**TO:** Nell Donaldson, Planner  
**FROM:** Lauren Swett, PE  
**DATE:** October 21, 2016  
**RE:** 23 Ocean Ave, Level III Site Plan Application

Woodard & Curran has reviewed the Level III Site Plan Application for the proposed redevelopment located at 23 Ocean Avenue. The project includes the construction of a new mixed use building and associated site improvements.

UNDERDRAIN DETAIL FOR ROOF DRAIN COLLECTION SYSTEM
NOT TO SCALE

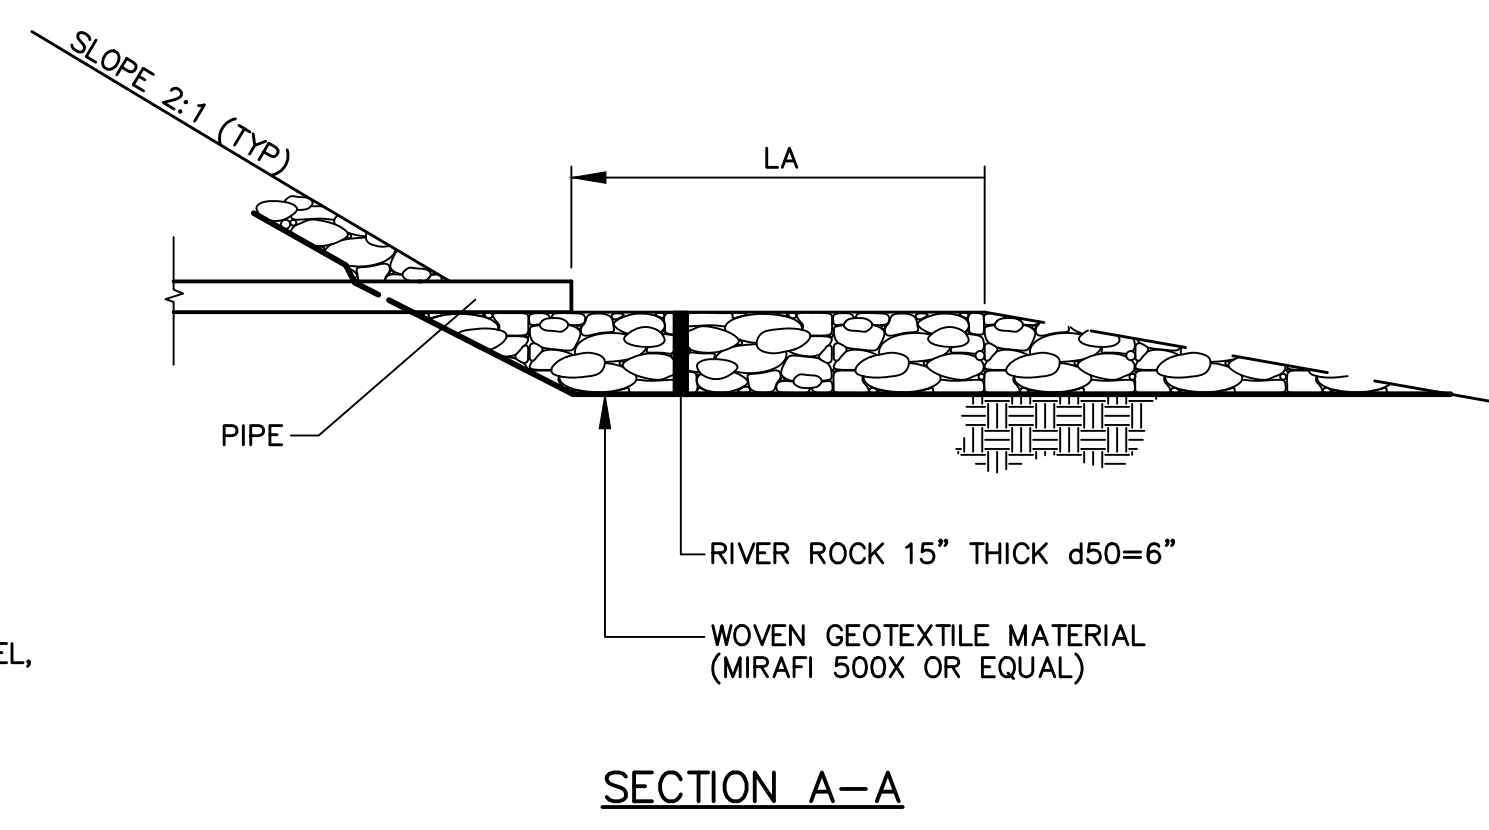
- b) General Standard: The project is required to include stormwater management features for stormwater quality control. A roof drain cartridge filter and an underdrained soil filter will be utilized to provide stormwater treatment on the site.

INLET PROTECTION - SILT SACK
NOT TO SCALE

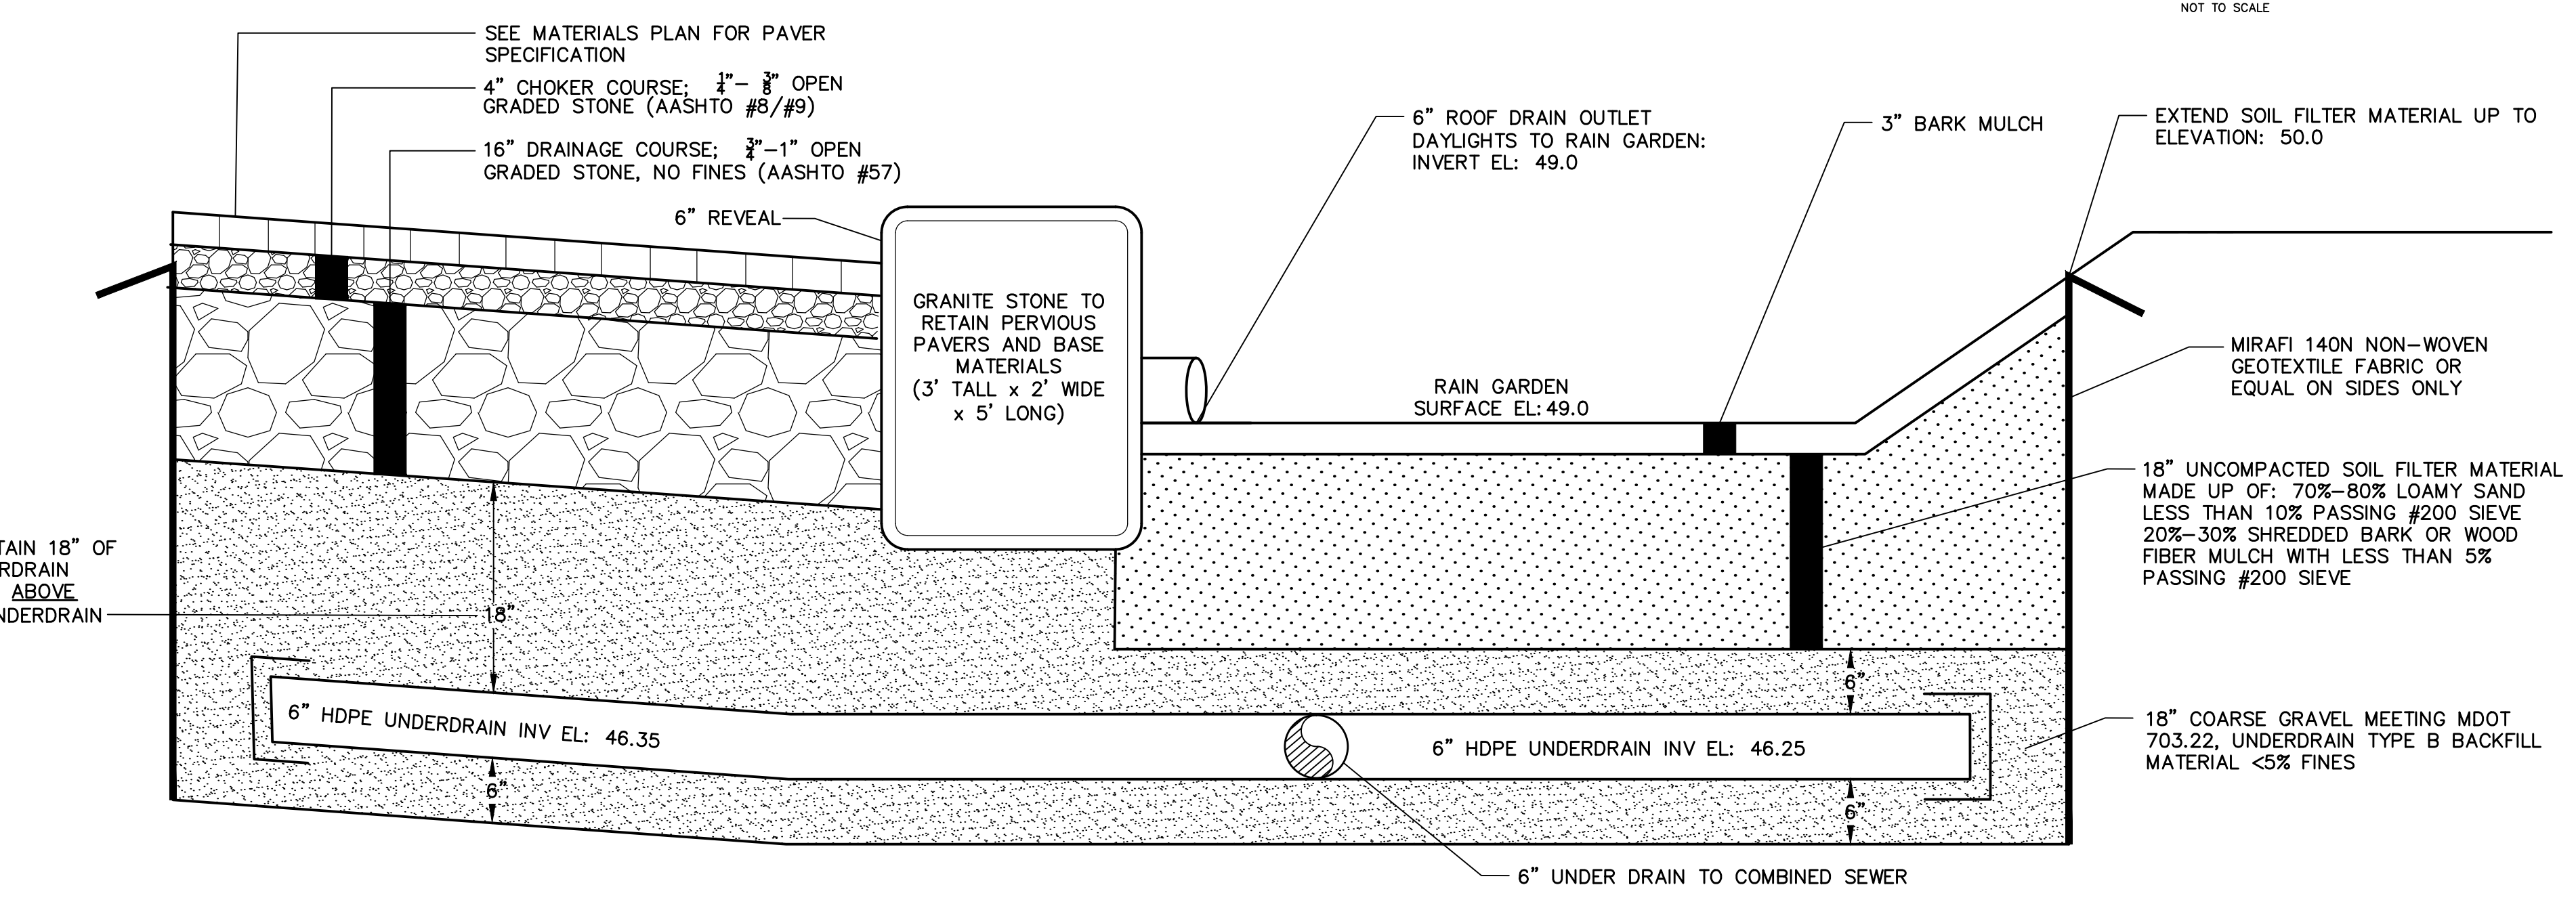
- a) Basic Standard: Plans, notes, and details have been provided to address erosion and sediment control requirements, inspection and maintenance requirements, and good housekeeping practices in accordance with Appendix A, B, & C of MaineDEP Chapter 500.
